LU/162/20/L

Listed building consent for the repointing of front elevation & replacement of rear doors.

Drawing title
Rear Elevation

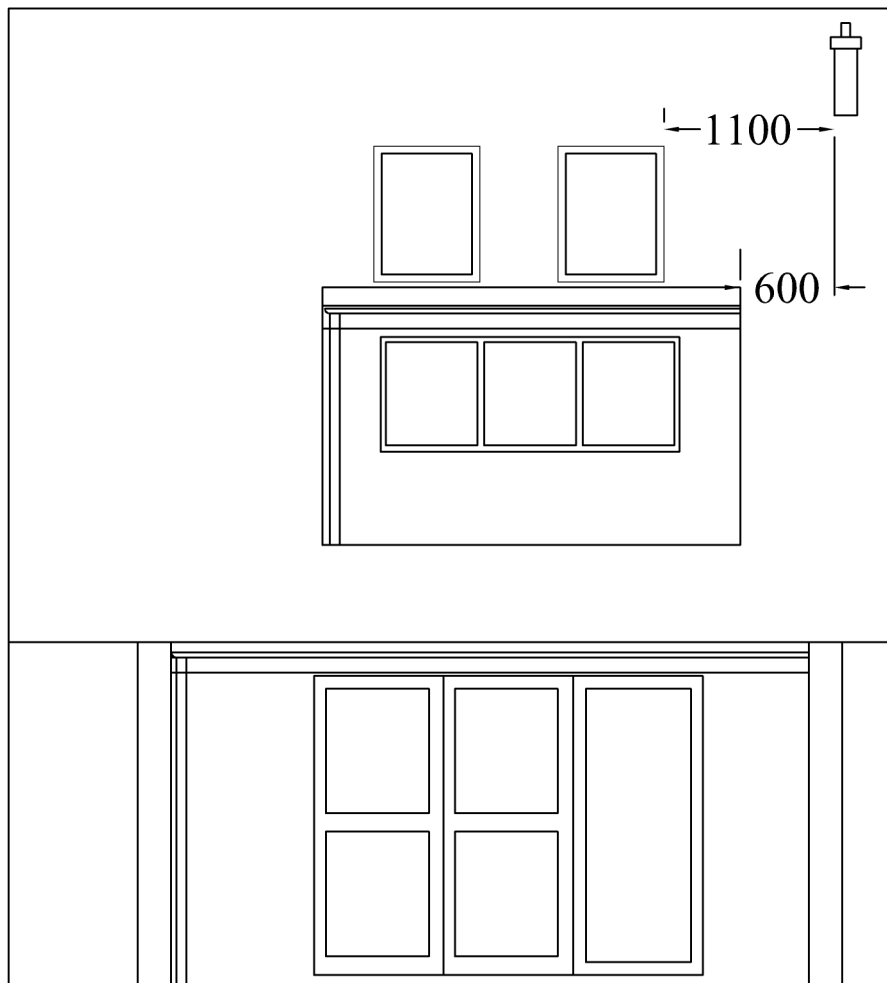
The proposal also includes the replication of the existing modern rear doors to the rear of the house. It is noted that the new doors will replicate the existing in terms of appearance and materials. Reference is made to the upgrading the doors, and if this is referring to the use of double glazing, it is suggested that this should be undertaken utilising the slimmer glazing units, as opposed to the standard ones. This element of the proposal seems to be acceptable as it only relates to modern fabric.
